Applicant: L & Q Estates

Proposal: Reserved Matters to 14/01932/OUT: Spine Road including landscaping and associated infrastructure

DATE: 21.07.2021

SECTION A - A
BLISTER BLOCK PAVING

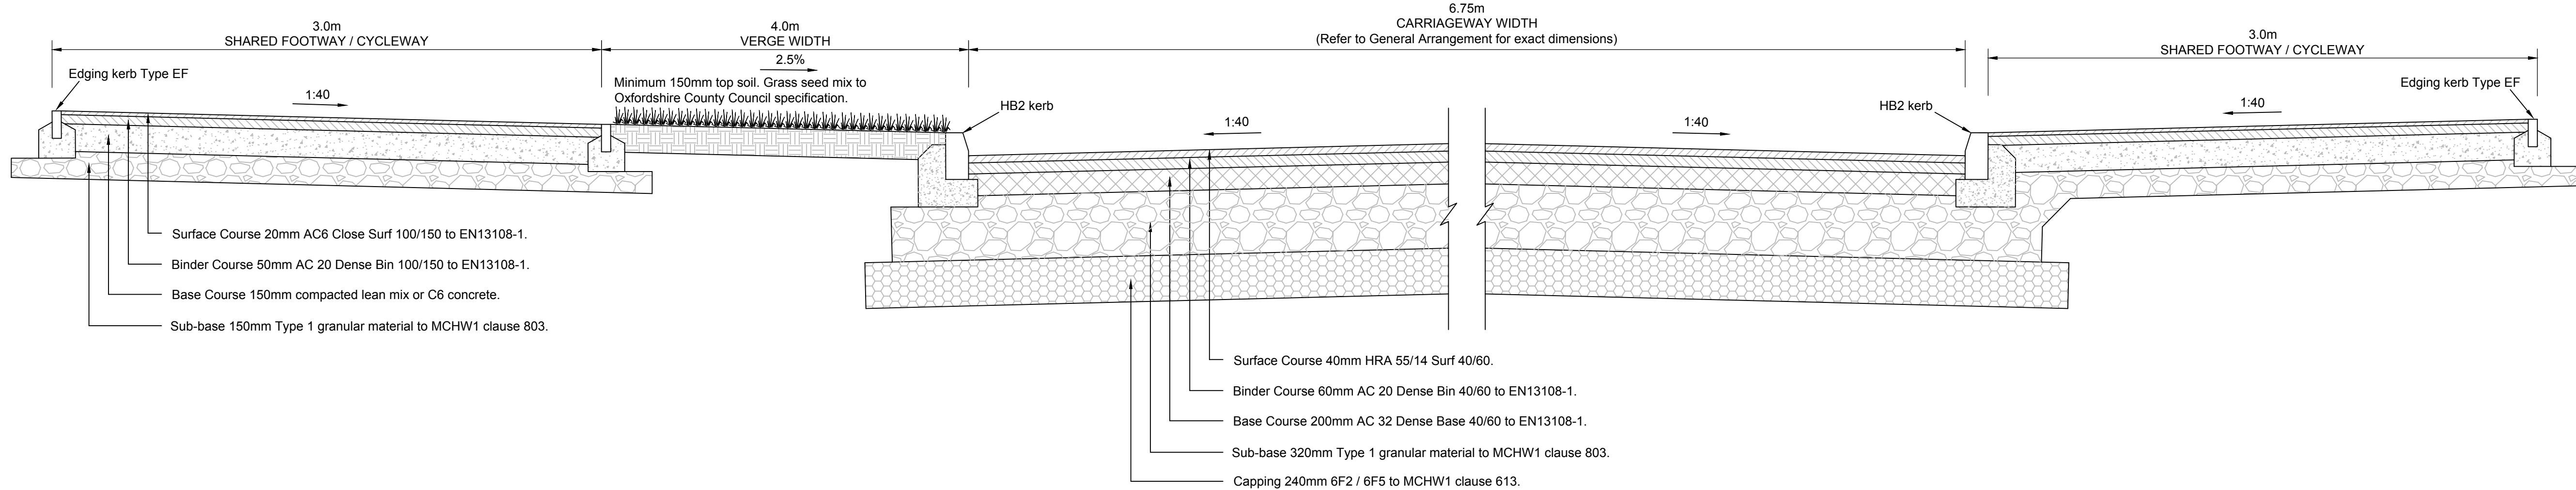
- 8.10. Block paving was shown for traffic calming areas, however, this was not considered acceptable as the spine road is a bus route and therefore prone to damage and the use of HRA with contrasting chippings or coloured tarmac on gentle raised tables was suggested as an alternative.
